**EN010117: Application by Rampion Extension Development Limited for the Rampion 2 Offshore Wind Farm**  
**The Examining Authority's Further Written Questions and requests for information**  
**Issued on Tuesday 18 June 2024**

Figure 7.2.2g (B) Woodland retention plan

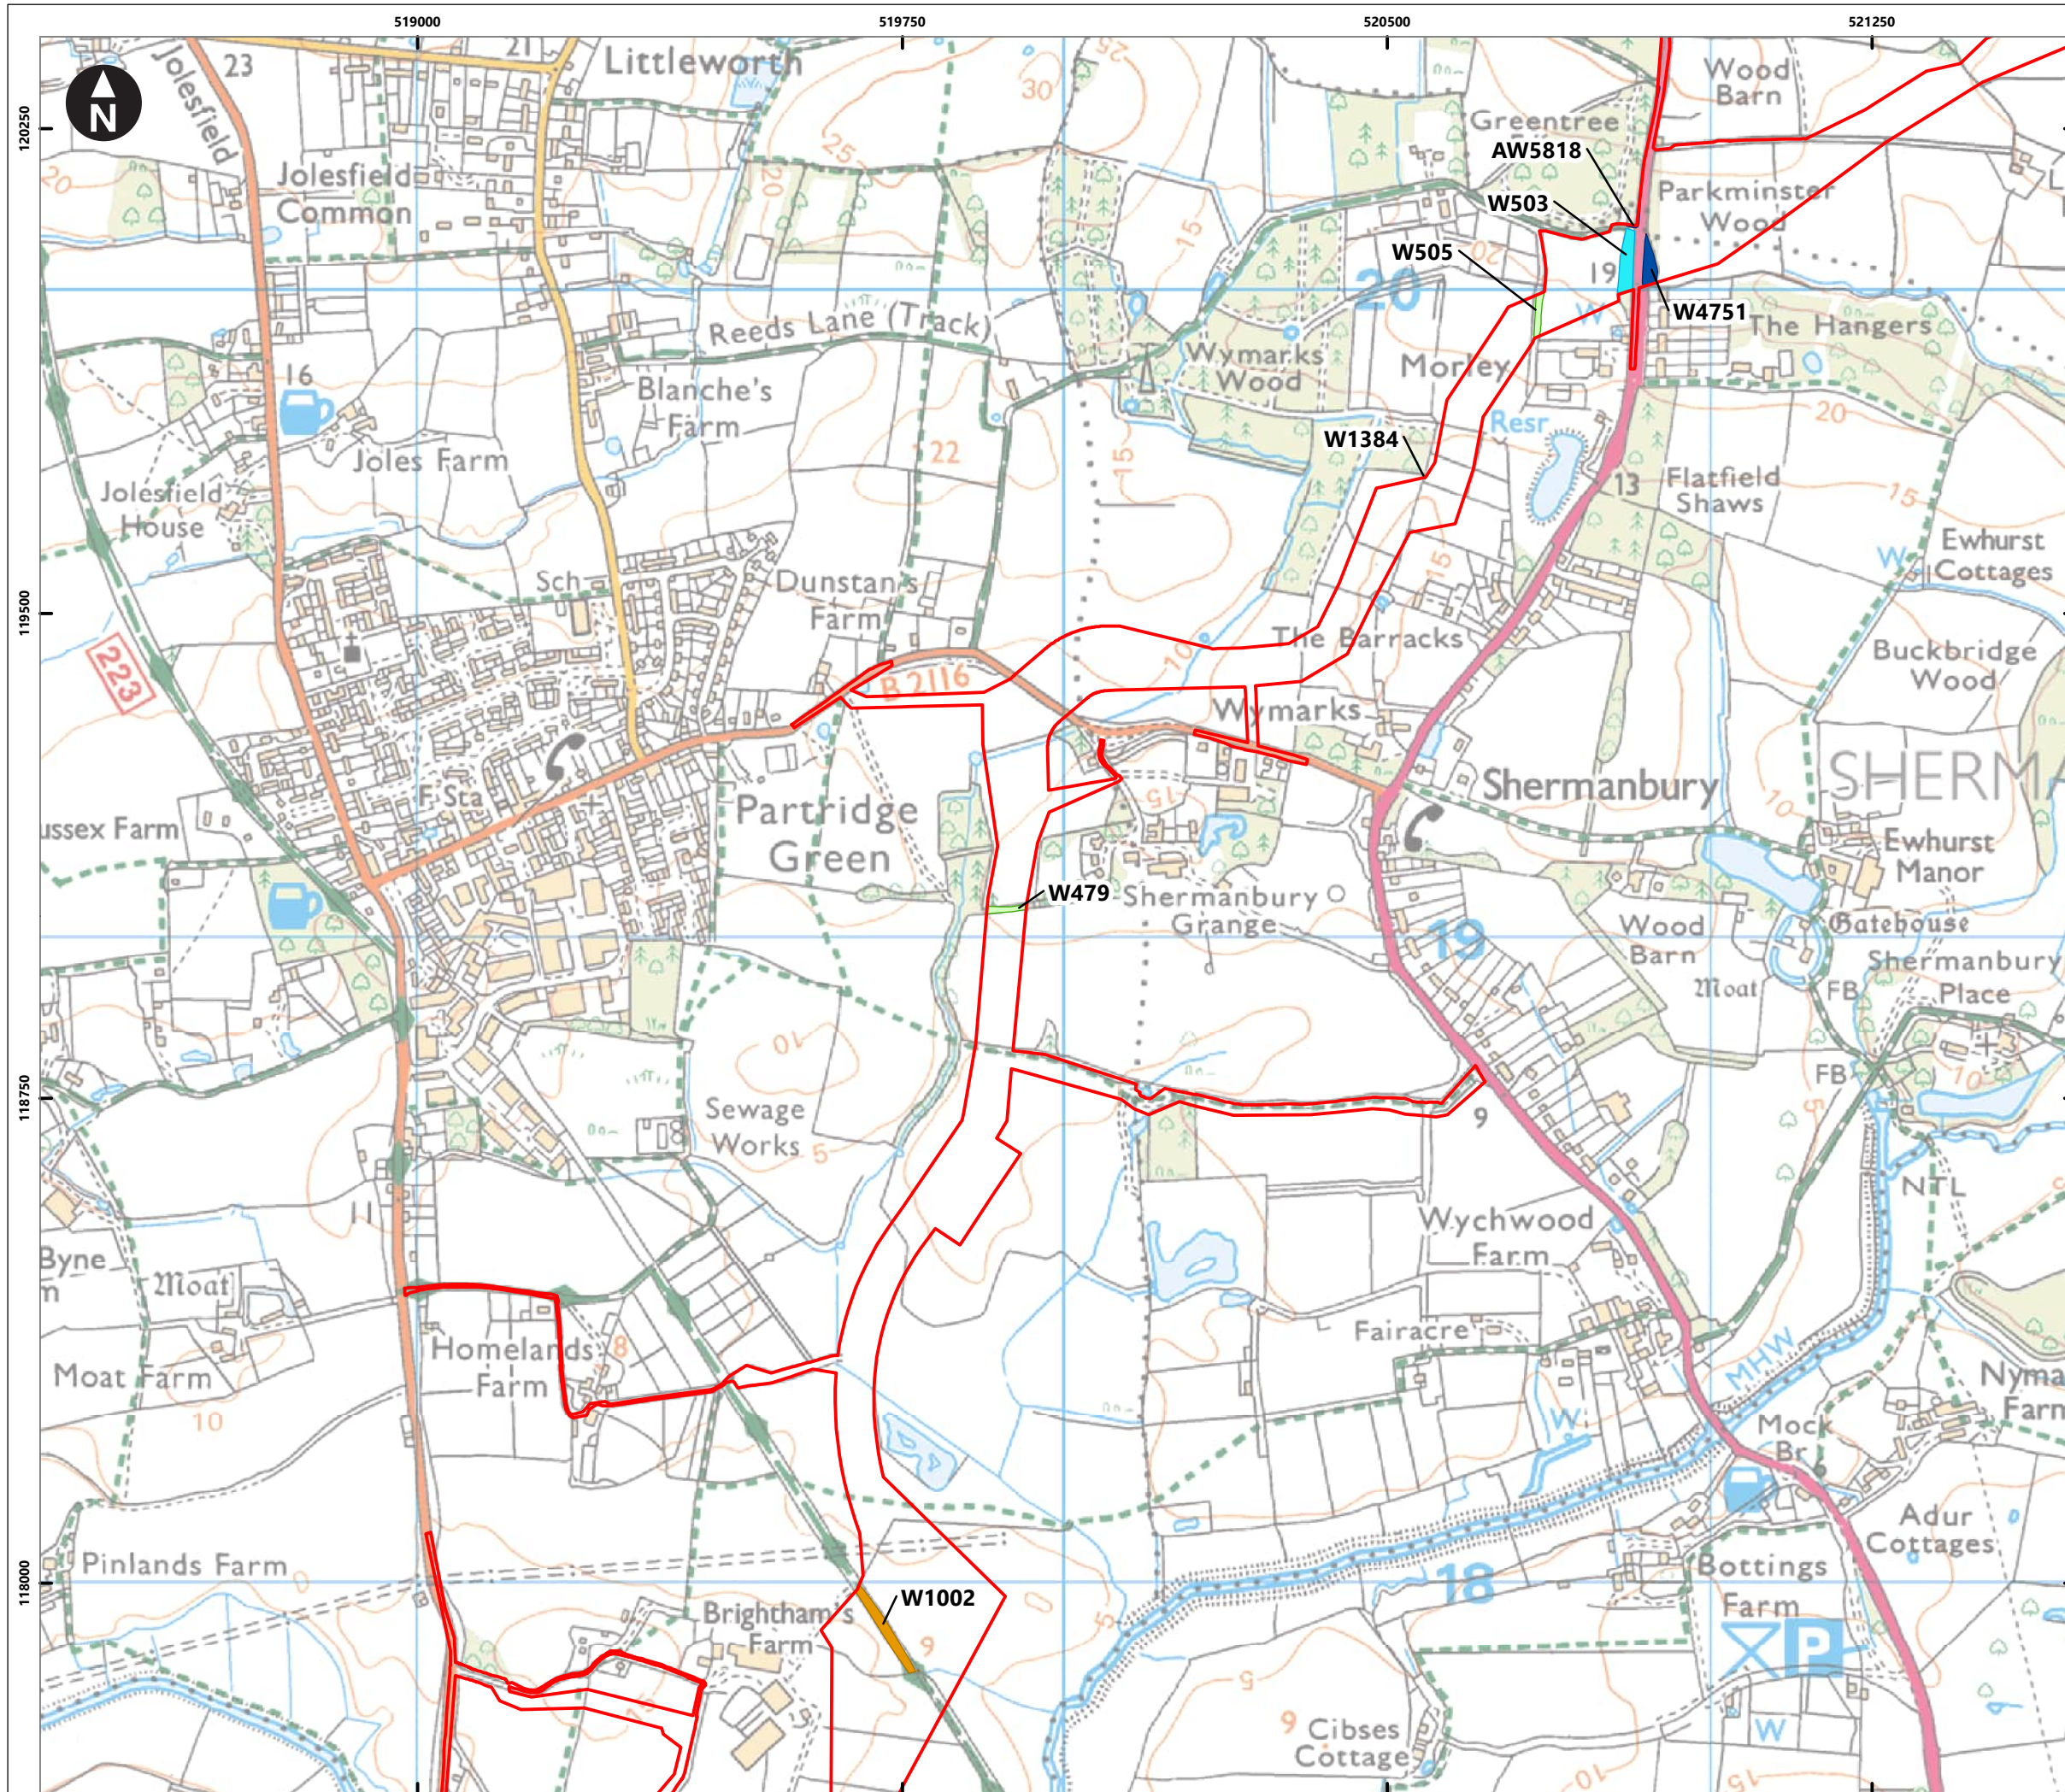
<p><b>The Applicant</b> <b>The Forestry Commission</b></p>	<p>avoid root damage. Confirm whether the Applicant intends to provide further evidence the relation to this matter.</p> <p><b>The Forestry Commission</b></p> <p>Provide a response if required.</p>
<p>TE 2.3</p>	<p><i>Priority Habitats - Potential Loss of Deciduous Woodland</i></p> <p><b>The Applicant</b> <b>West Sussex CC</b> <b>The Forestry Commission</b></p>	<p><b>The Applicant</b></p> <p>Comment on the West Sussex CC response [REP4-086] at Deadline 4 to TE1.6 which states:</p> <p><i>“The Woodland Retention Plan, Figure 7.2.2h (B) of the OCoCP [REP4-043], identifies the area of deciduous woodland status within the National Grid Bolney substation as being retained (ref. W3713). This finding is contrary to that stated within the Applicant’s response, as well as plans shown within inset 45 of the Arboricultural Impacts Plan found within the Arboricultural Impact Assessment [APP-194], as well as what can be achieved within the indicative plan for the AIS extension option without adverse impact (as shown within the Design and Access Statement). [REP3-013]. Therefore West Sussex CC remains unsatisfied that the impact on deciduous woodland, a priority habitat, are at all clear at this location.”</i></p> <div style="display: flex; align-items: flex-start;">  <div style="margin-left: 20px;"> <p>Screenshot from Inset 45 of the updated Arboricultural Impact Assessment submitted at Deadline 4 [REP4-037] indicating a section of W67 (trees not surveyed in detail) indicated in the key as ‘trees to be removed’ (indicated in red)</p> </div> </div>

Screenshot from Figure 7.2.2h (B) Woodland retention plan in the OCoCP [REP4-043] indicating W3713 shaded blue defined in the key as 'retained'.
